# Site Plan\_V1.pdf Markup Summary

PLOT PLAN

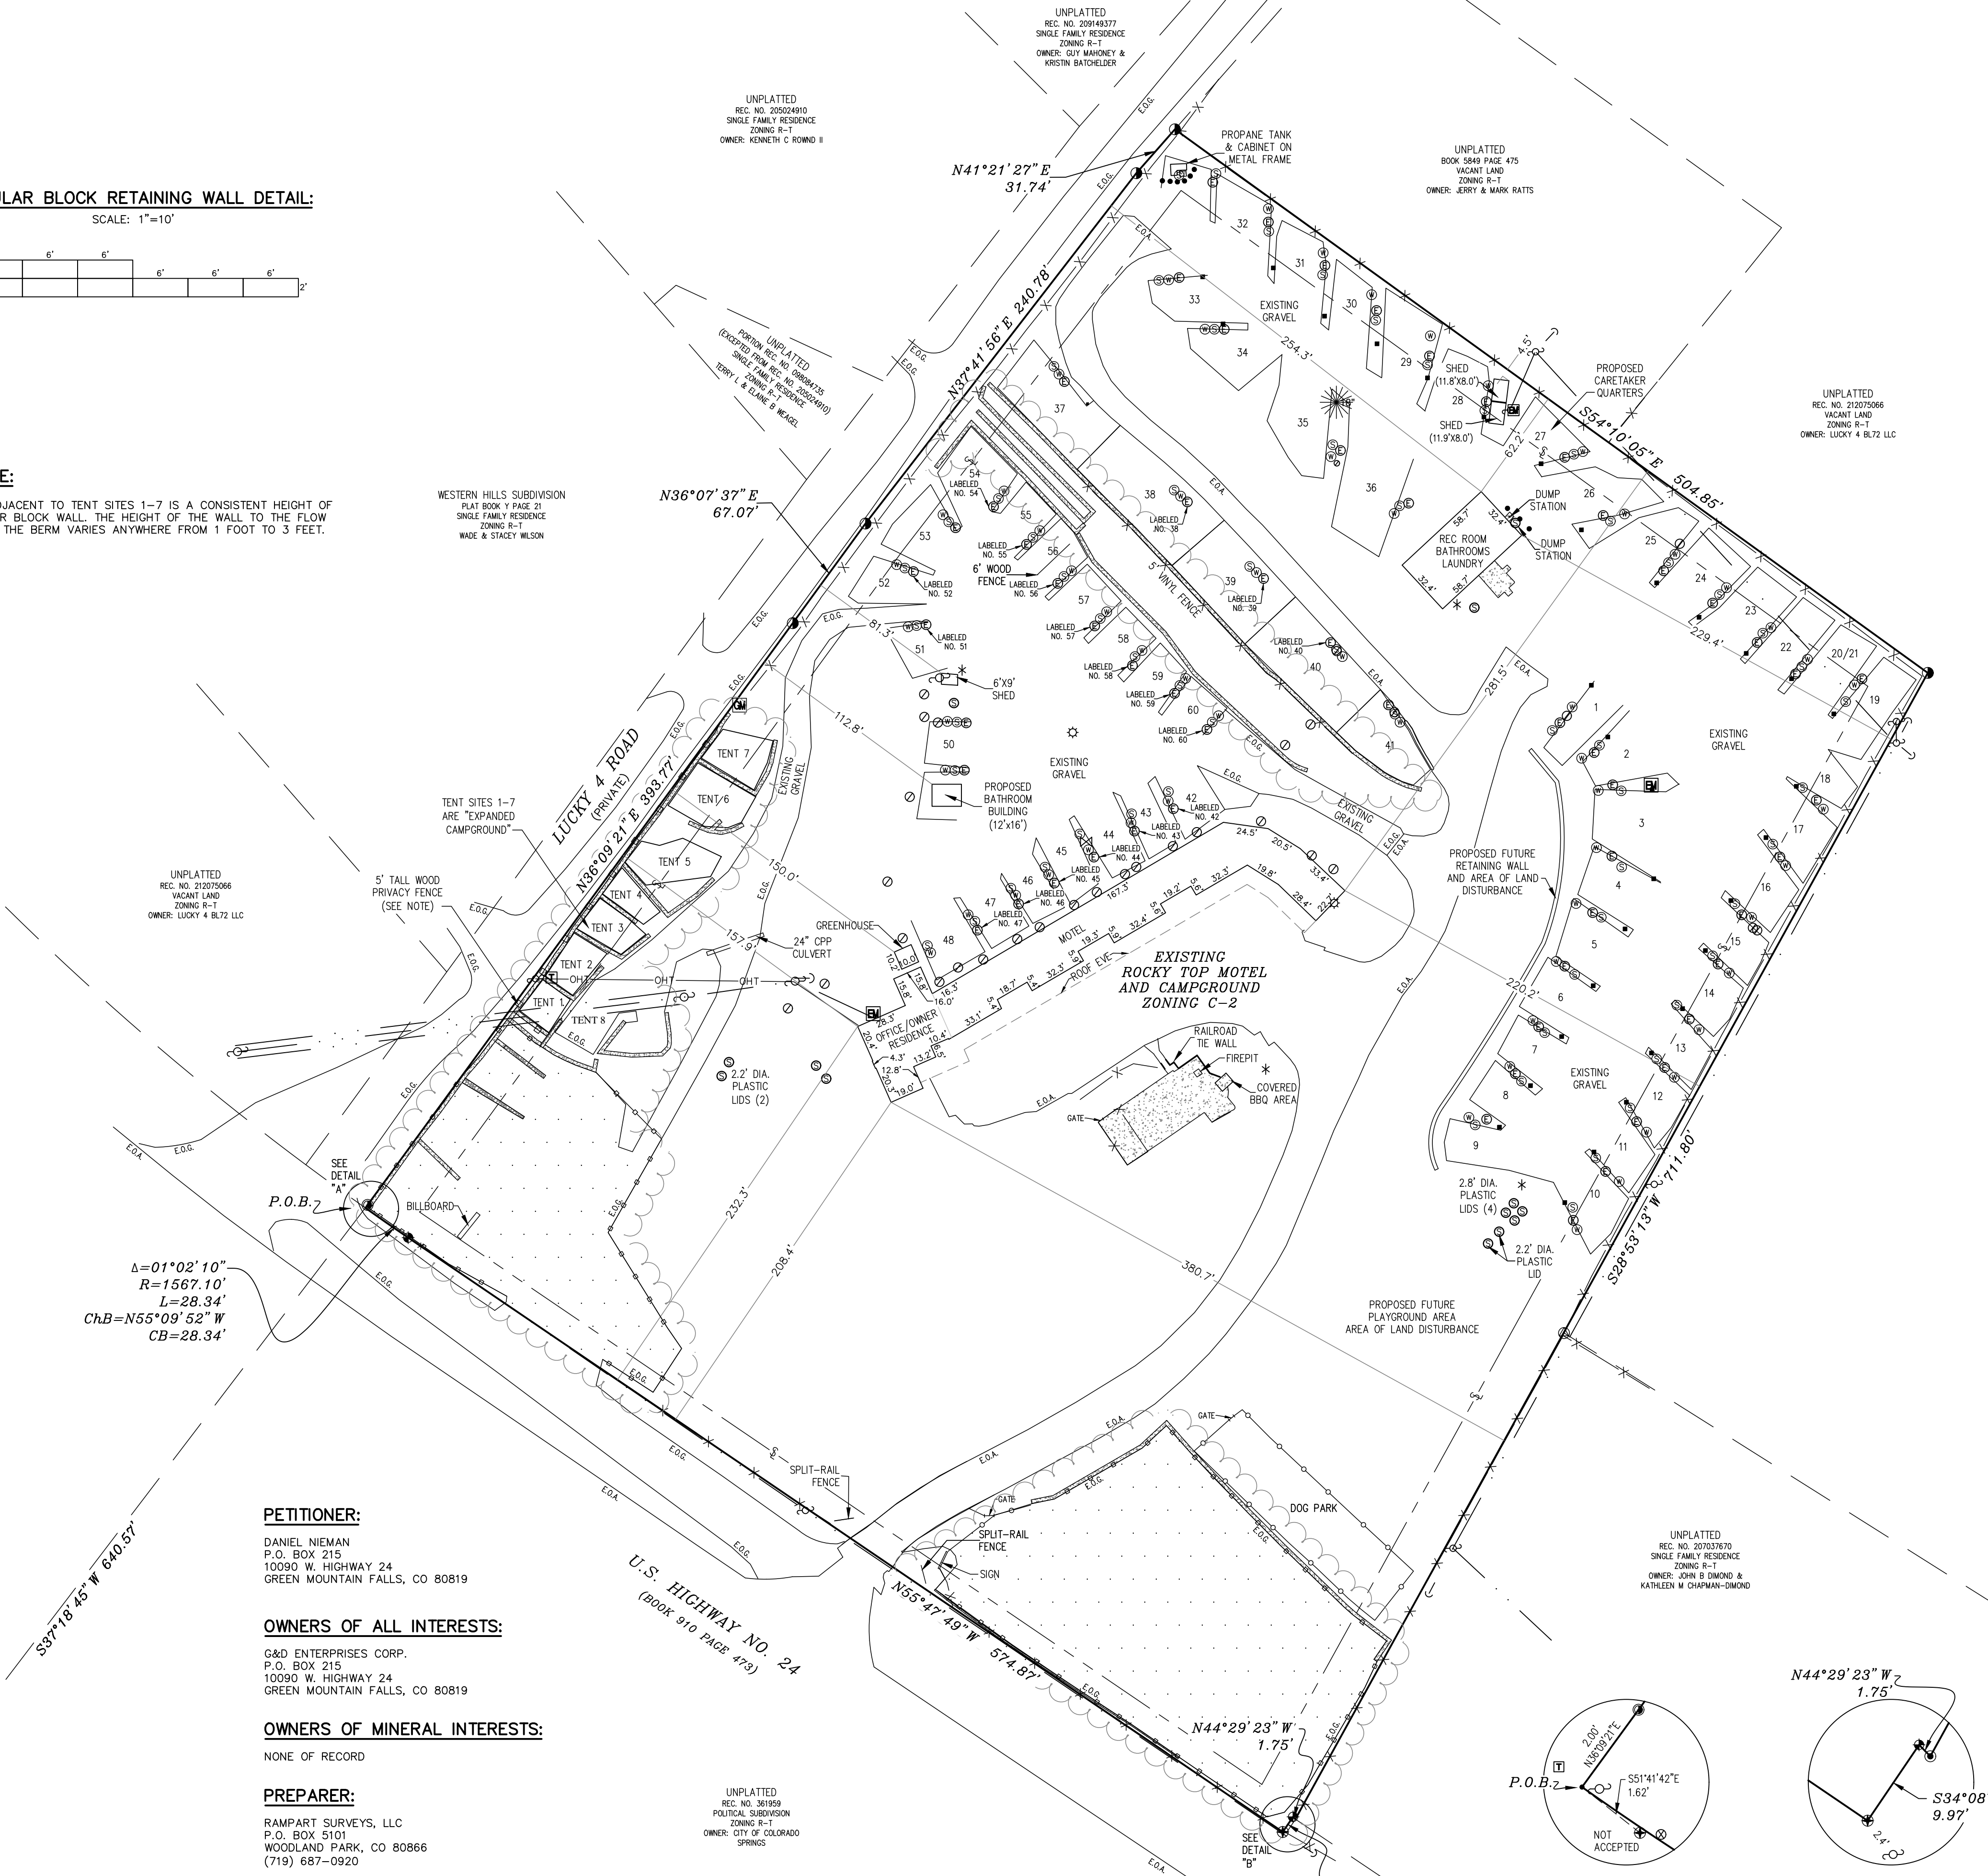
Needs Clearance from Fire District

Screening not depicted, a wire fence is not 100% opaque, please refer to Section 5.2.37 of the LDC for storage of vehicles. This is also a part of the Letter of Intent and how the applicant is intending to meet the Criteria of Approval.

Letter of Intent indicates 2 full-time residences, site plan only shows one care-takers quarters.

See comments on Letter of Intent in regards to signage. Only 1 per street frontage is permitted in the C-2 zoning

not mentioned anywhere in application
